DECISION DELEGATED TO HEAD OF PLANNING

Application No: H20-0274-25 **Applicant:** Mr & Mrs Parsons
Proposal: Single storey rear extension & detached garage to existing dwelling
Location: Field View Old Fendyke Sutton St James
Terminal Date: 5th June 2025

LOCATION & SITE PLAN(S)

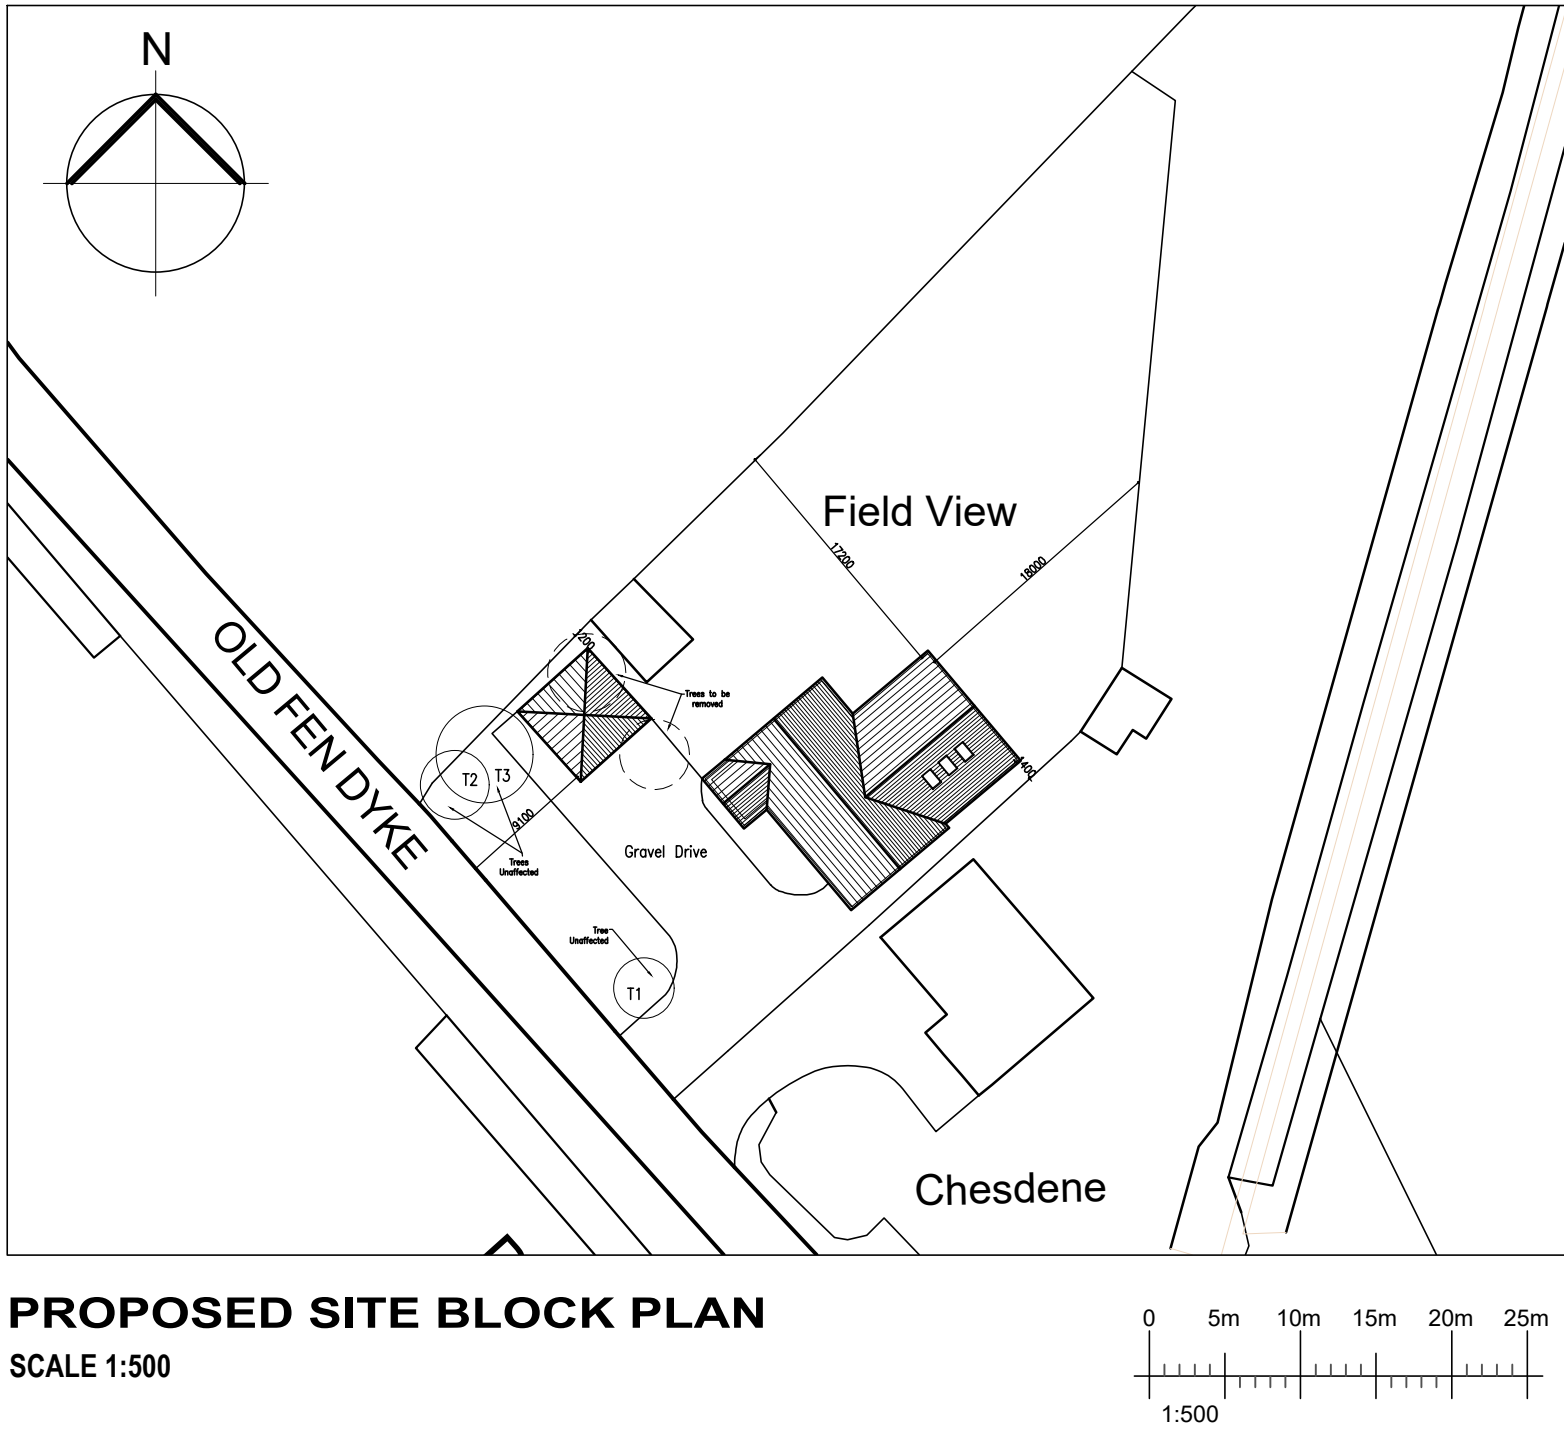
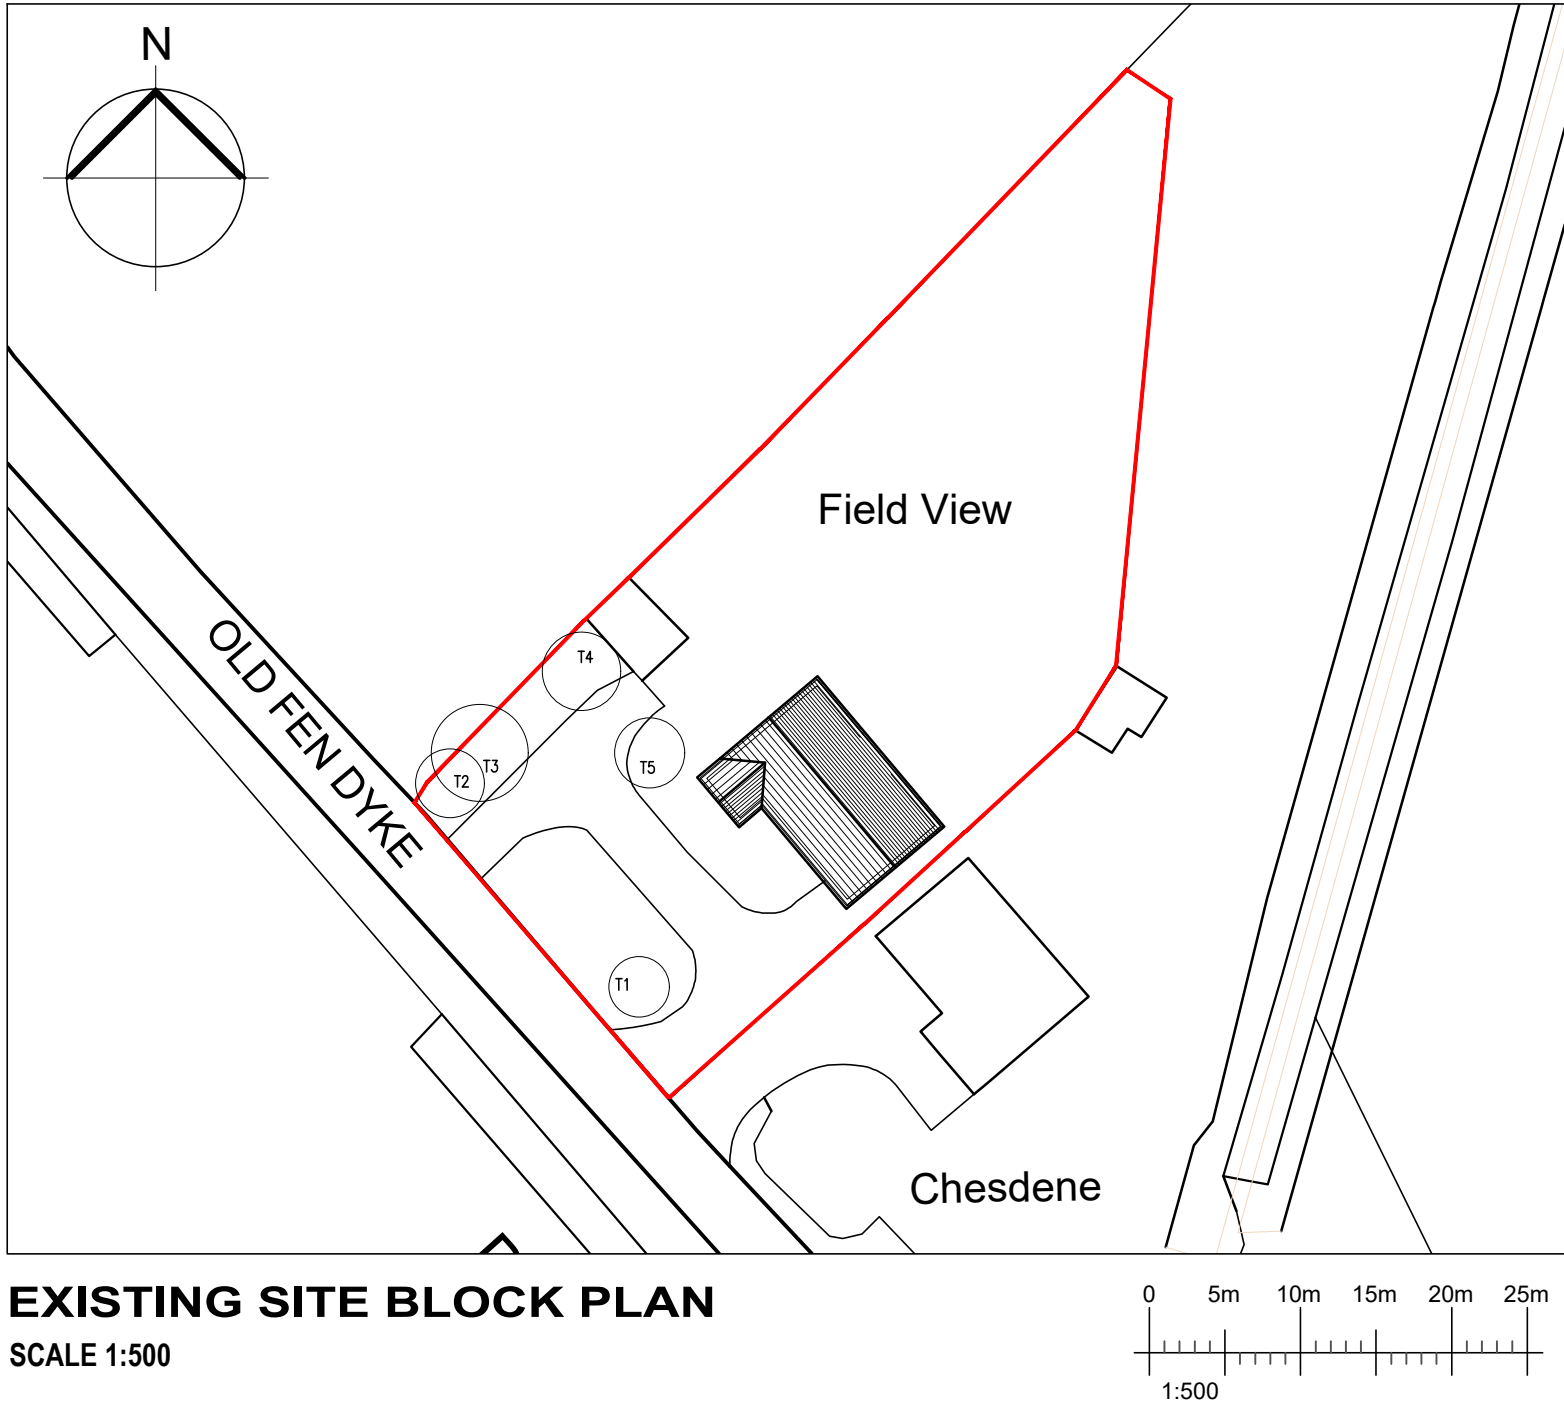
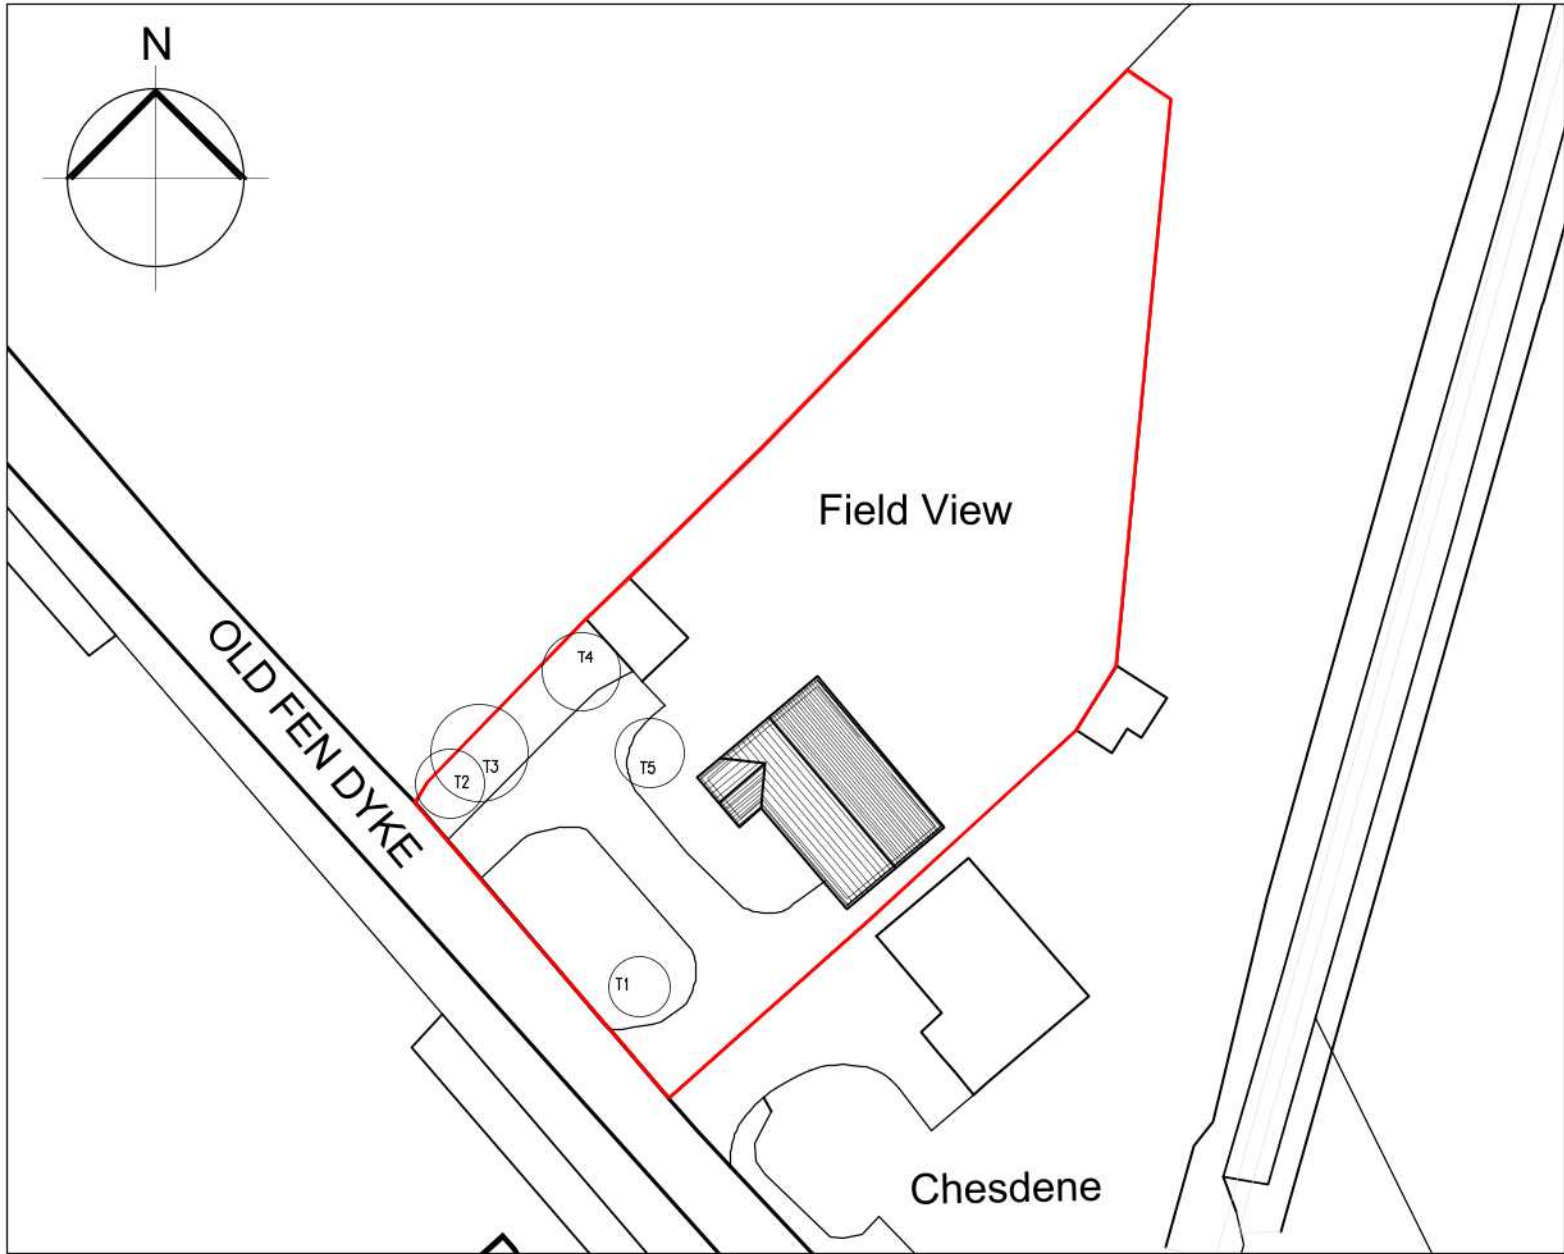
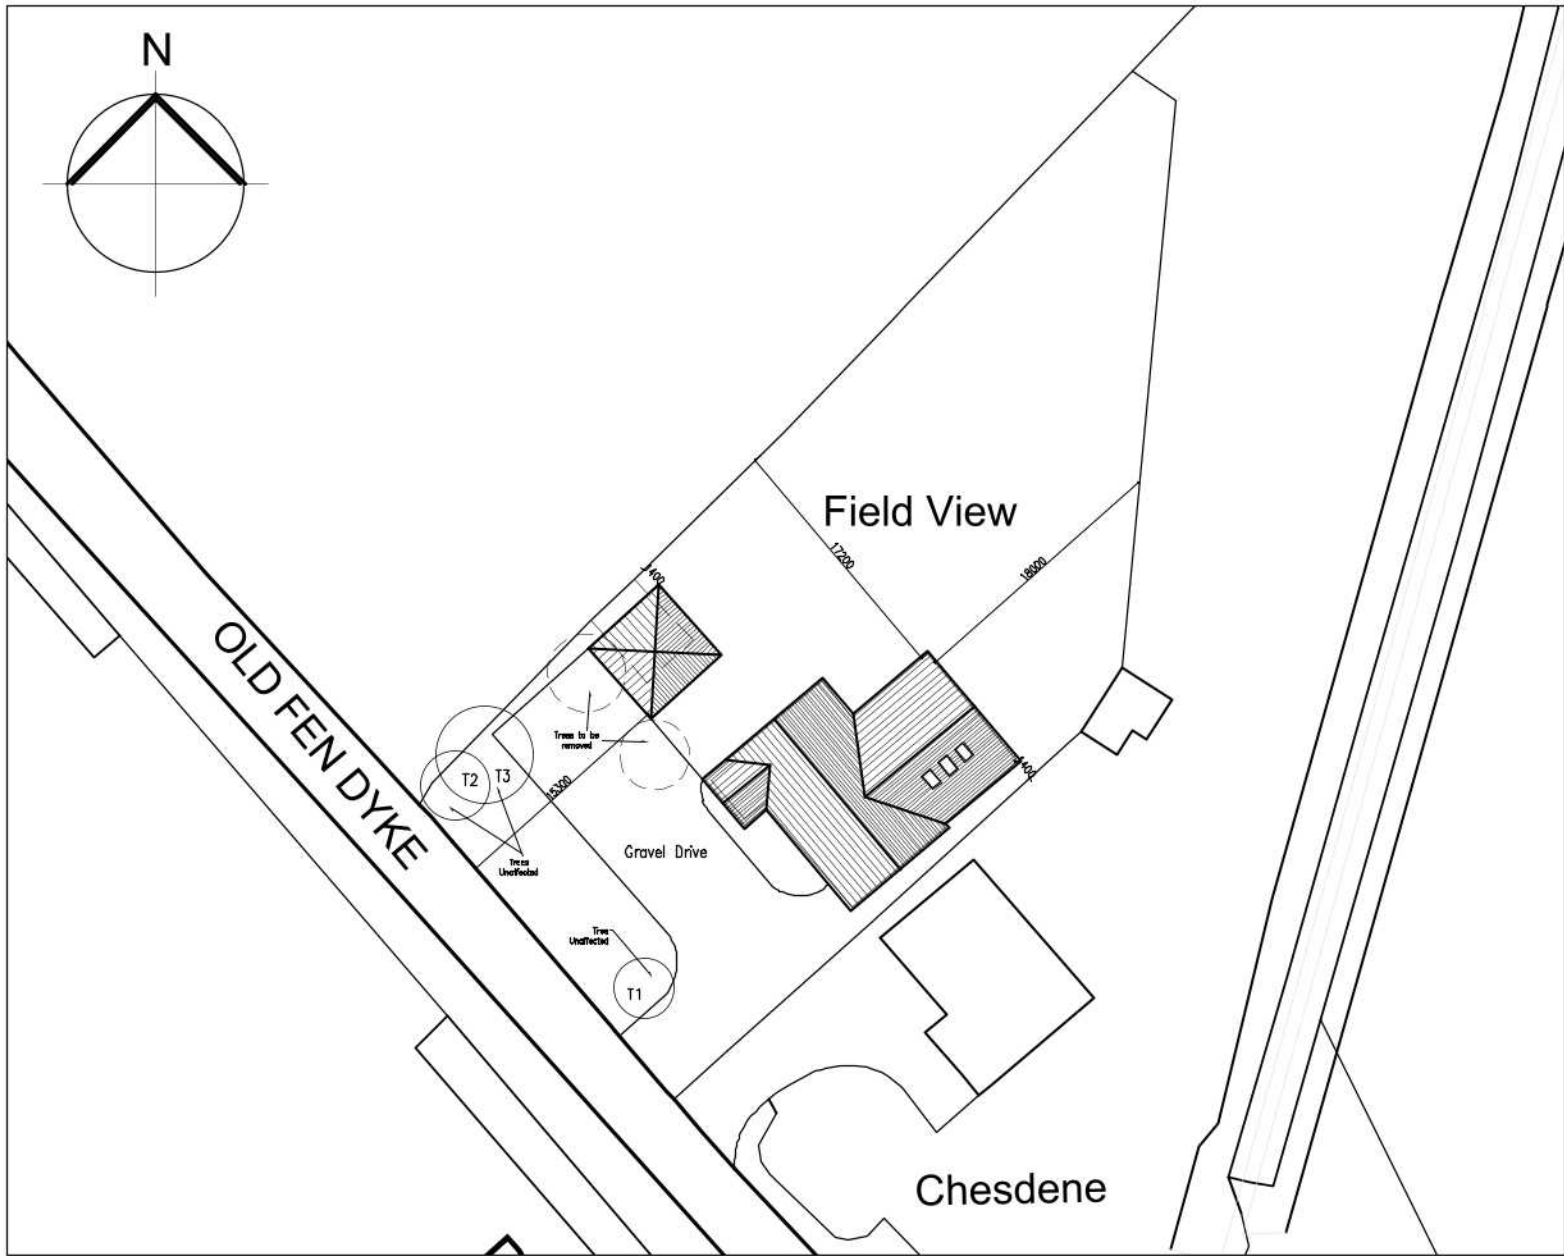
The proposal has been amended throughout the course of the application. The original submission comprised the location of the garage being forward on the front elevation of the dwelling. The garage has now been relocated to the side of the existing dwelling resulting in a more acceptable design.

There are two existing access points into this site. The access furthest north will need to be formally stopped up and the access that will remain shall be upgraded to Lincolnshire County Council Specification - a note should be added to the proposed site plan indicating this.

There are currently two existing access points into this site. LCC Highways have been consulted and have requested that the access furthest north will need to be formally stopped up with remaining access being upgraded to Lincolnshire County Council Specification, this has been secured by a condition.
